**REQUEST**

Current Zoning: CG (general commercial)  
Proposed Zoning: MUDD-O (mixed use development district, optional)

Approximately 1.63 acres located along the northeast side of East 7th Street, south of Lamar Avenue, and north of Clement Avenue.

**STAFF RECOMMENDATION**

TECHNICAL DATA SHEET

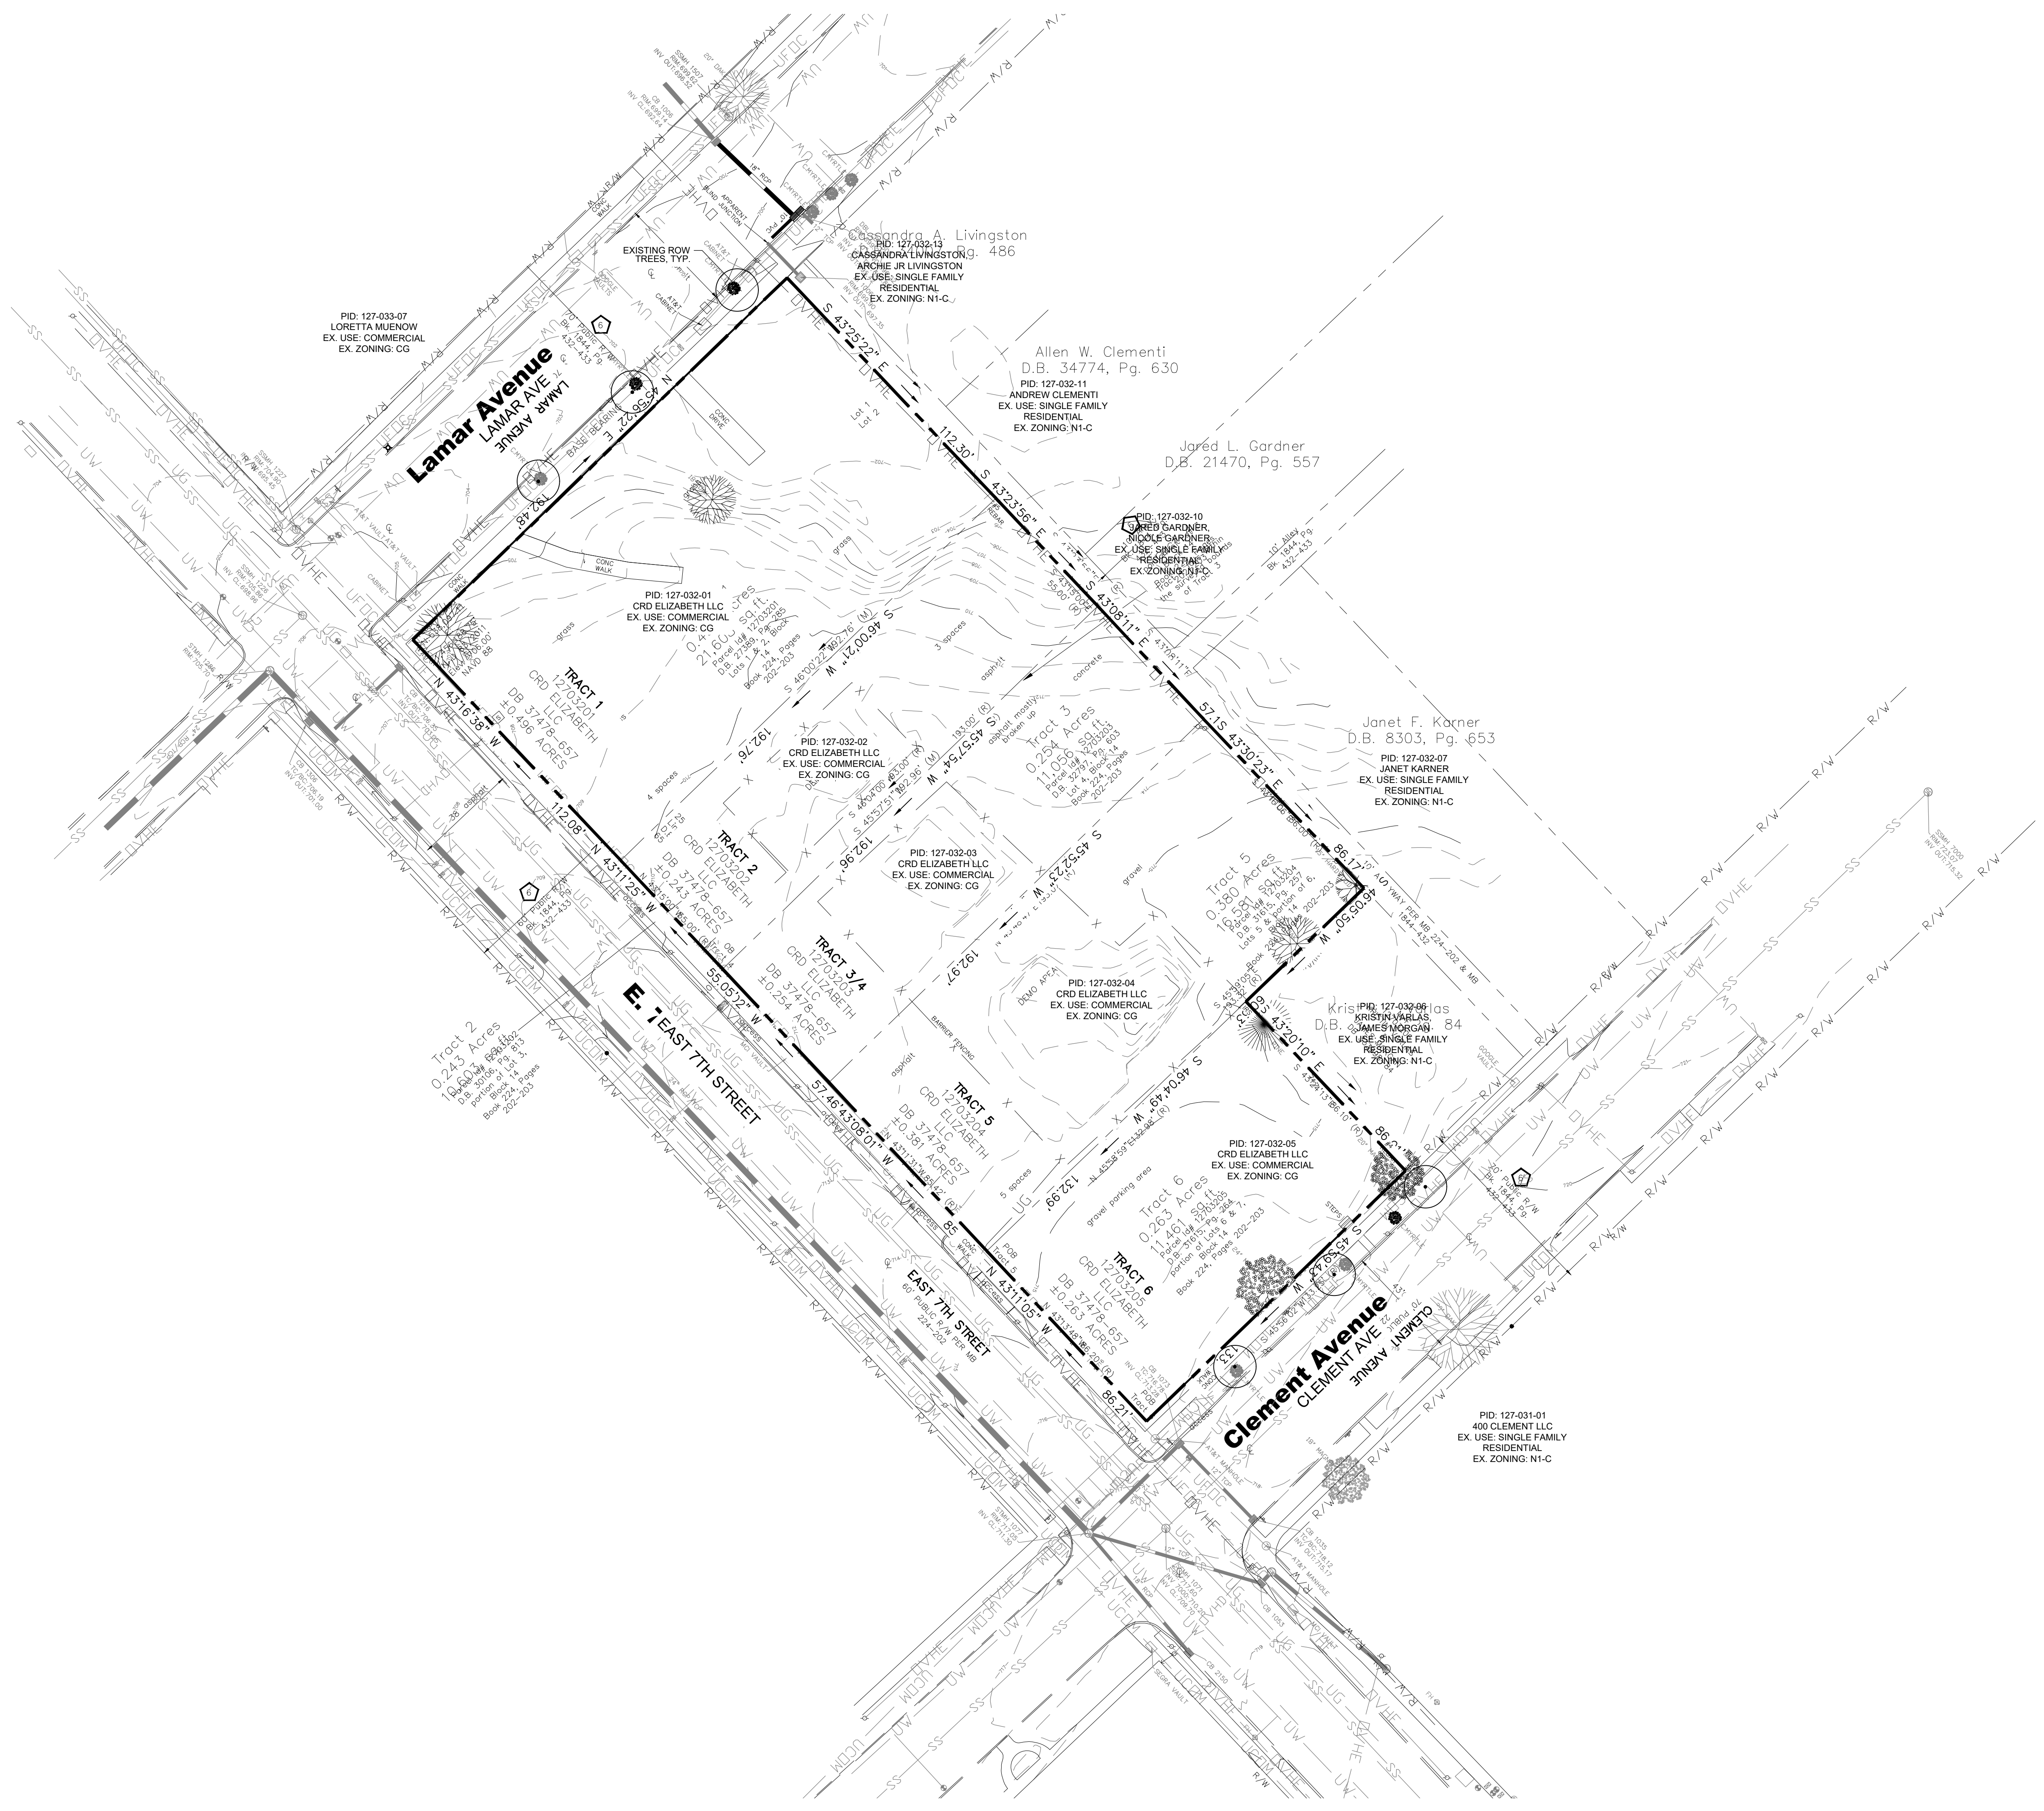
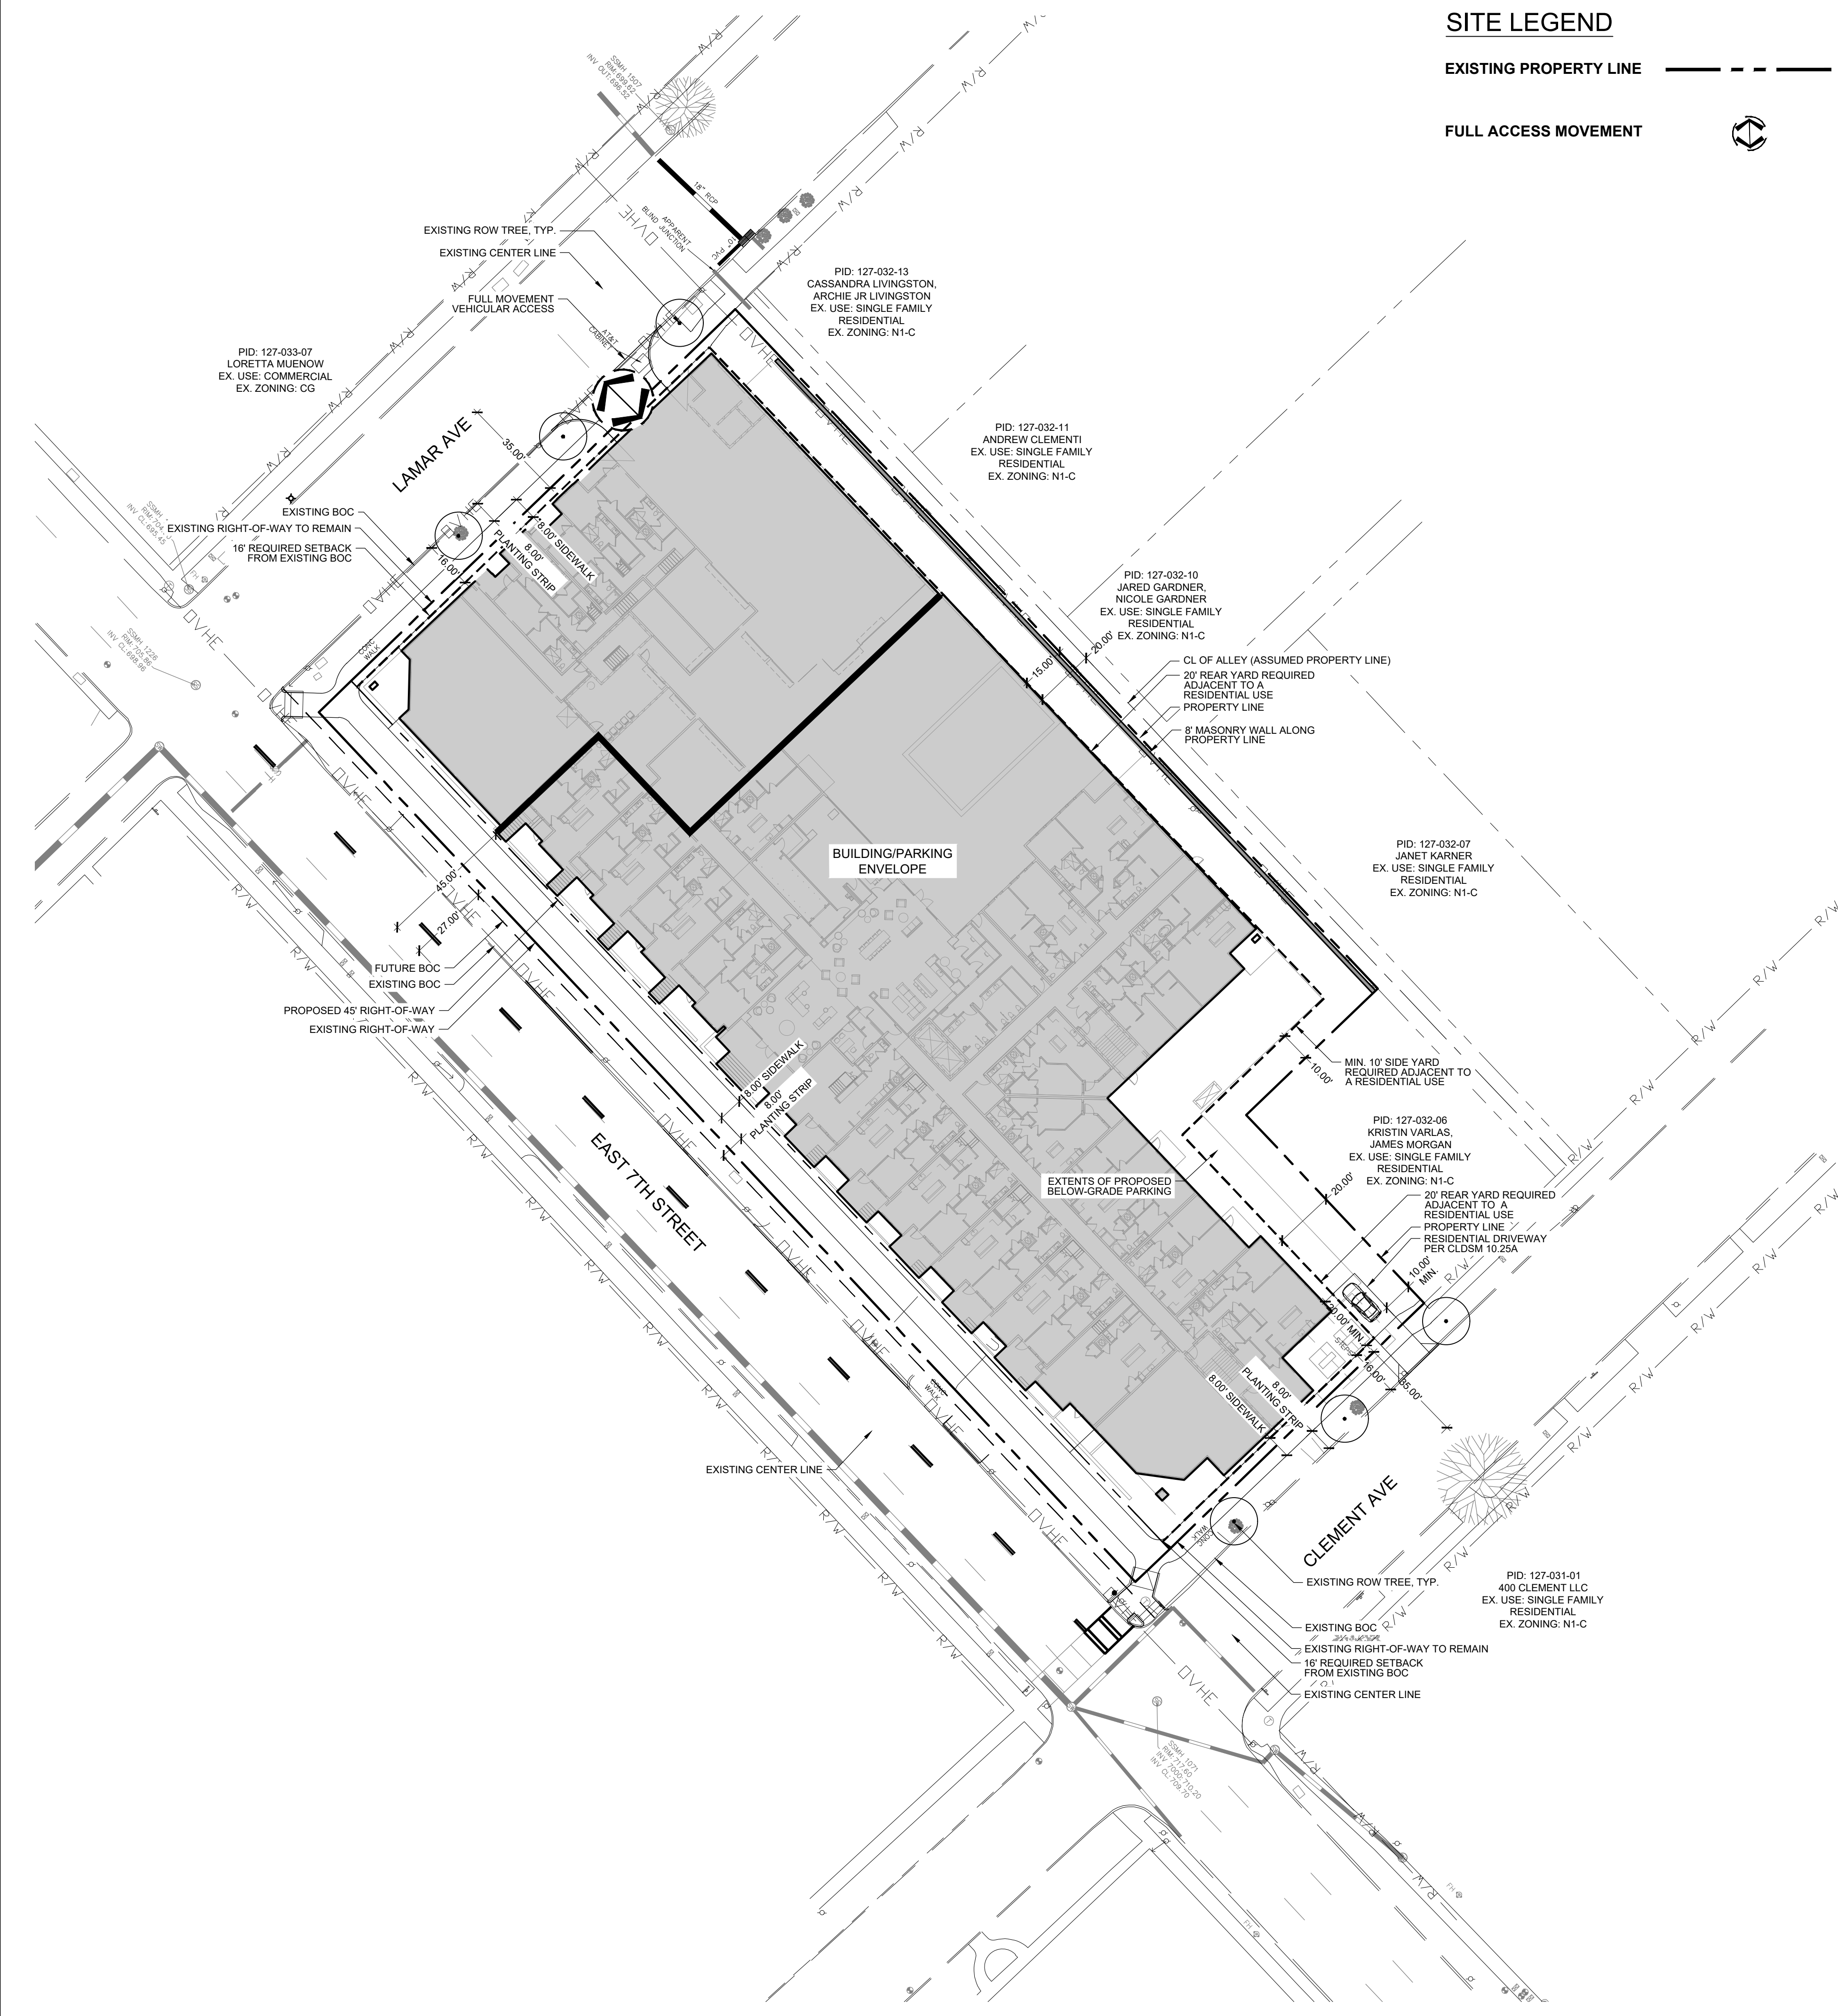
6. Edit the listed number of residential units under the general provisions to note 175 rather than 213.

HEIGHT PLANE EXHIBITS

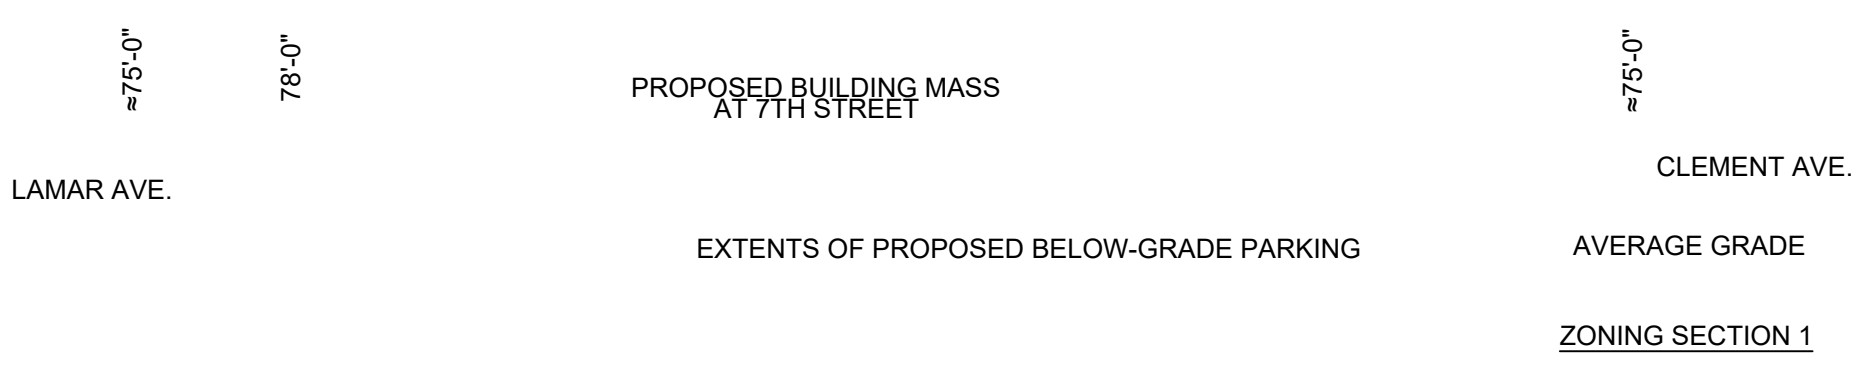
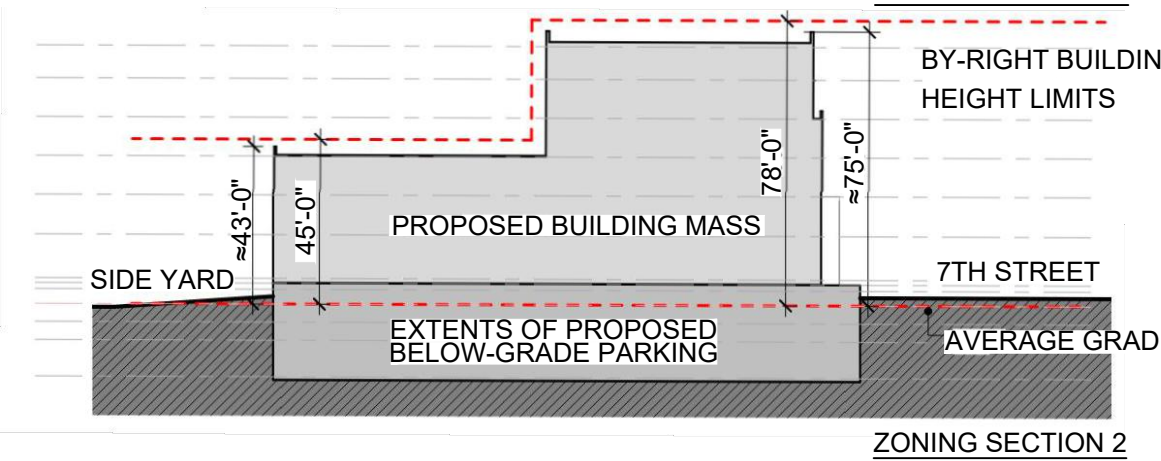
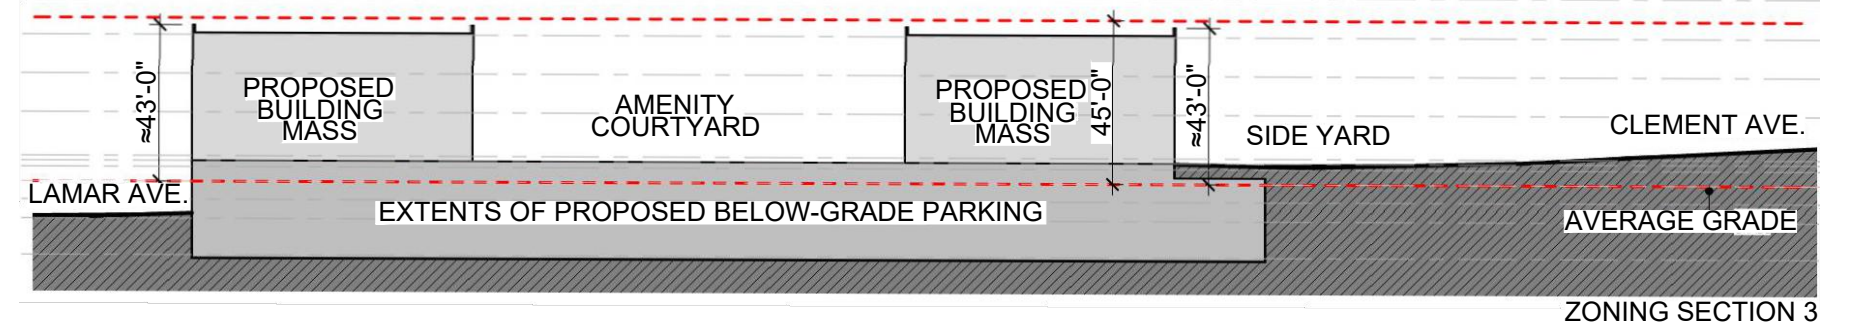
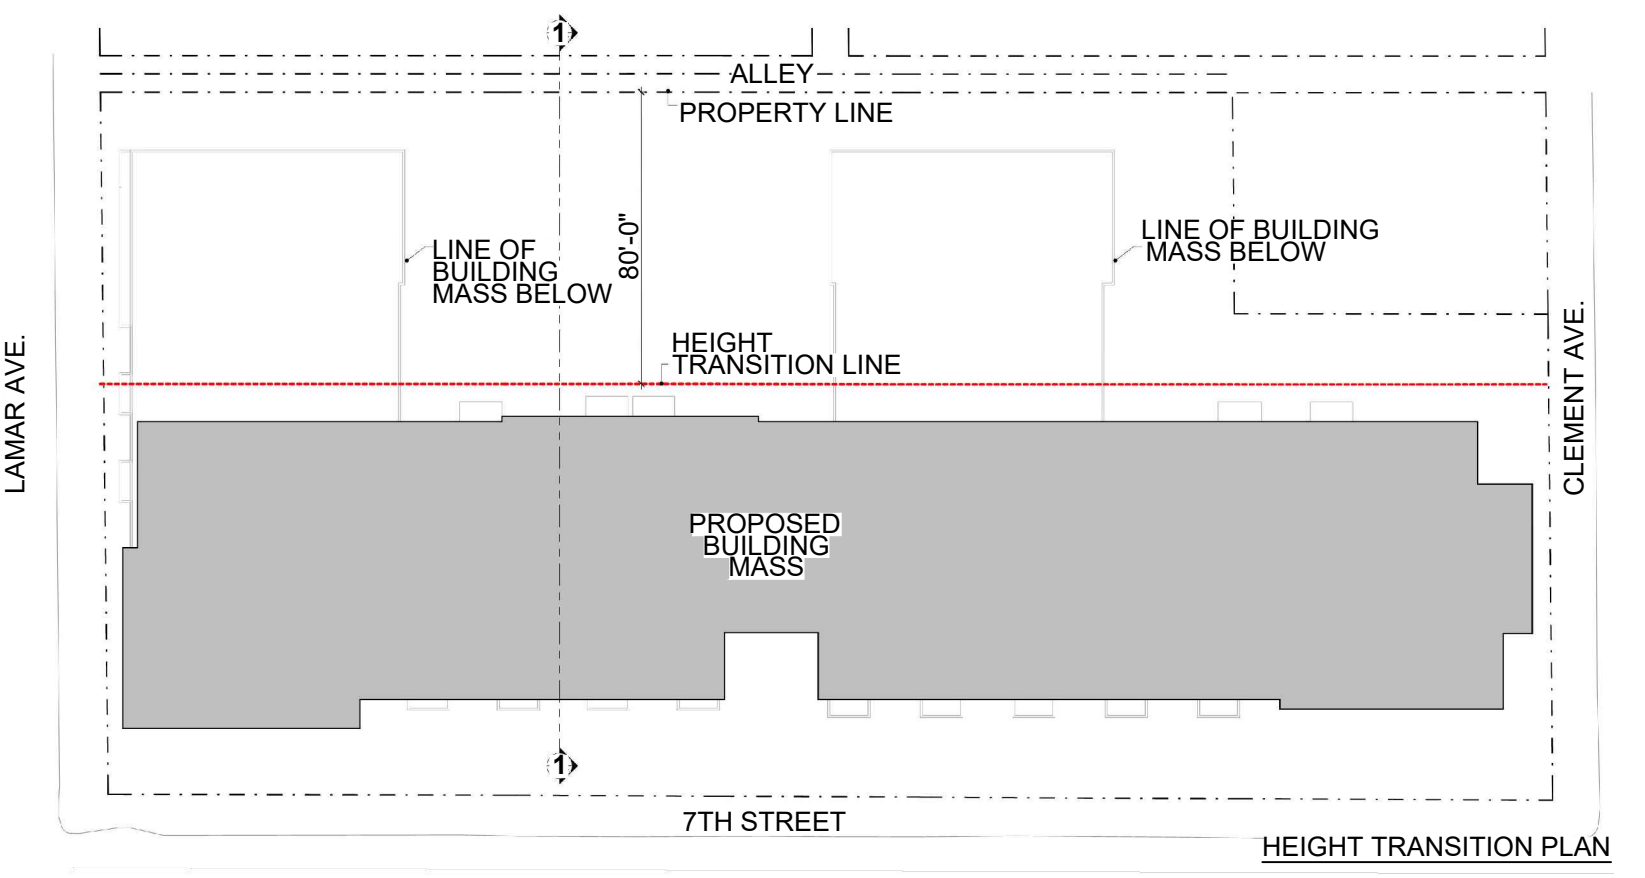
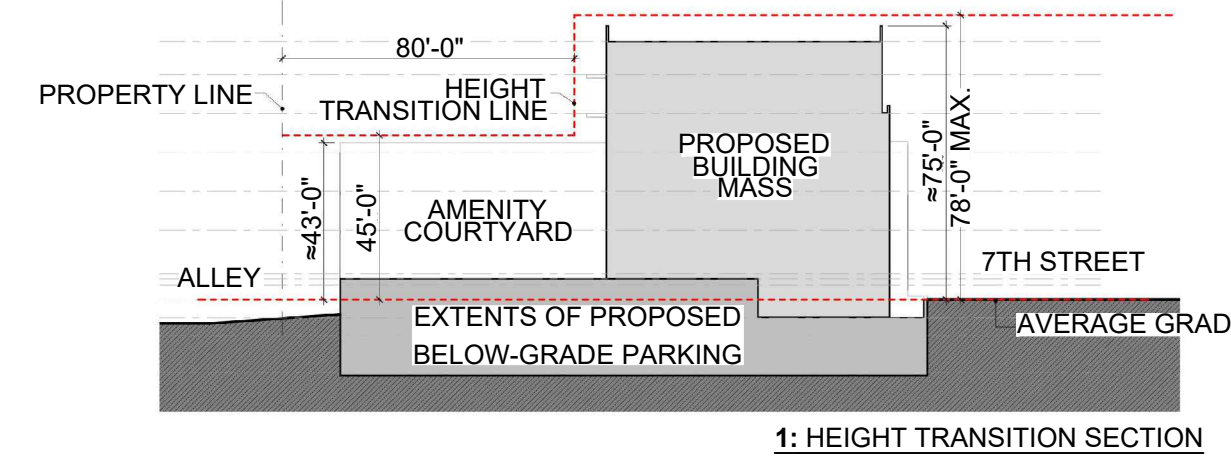
5. ~~Reduce the maximum building height to 65' and revise the proposed height transition detailed in the height plane exhibits and conditional notes so that no portion of the proposed building exceeds 50' in height when located within 100' of property lines in the Neighborhood 1 Place Type.~~ **Addressed**
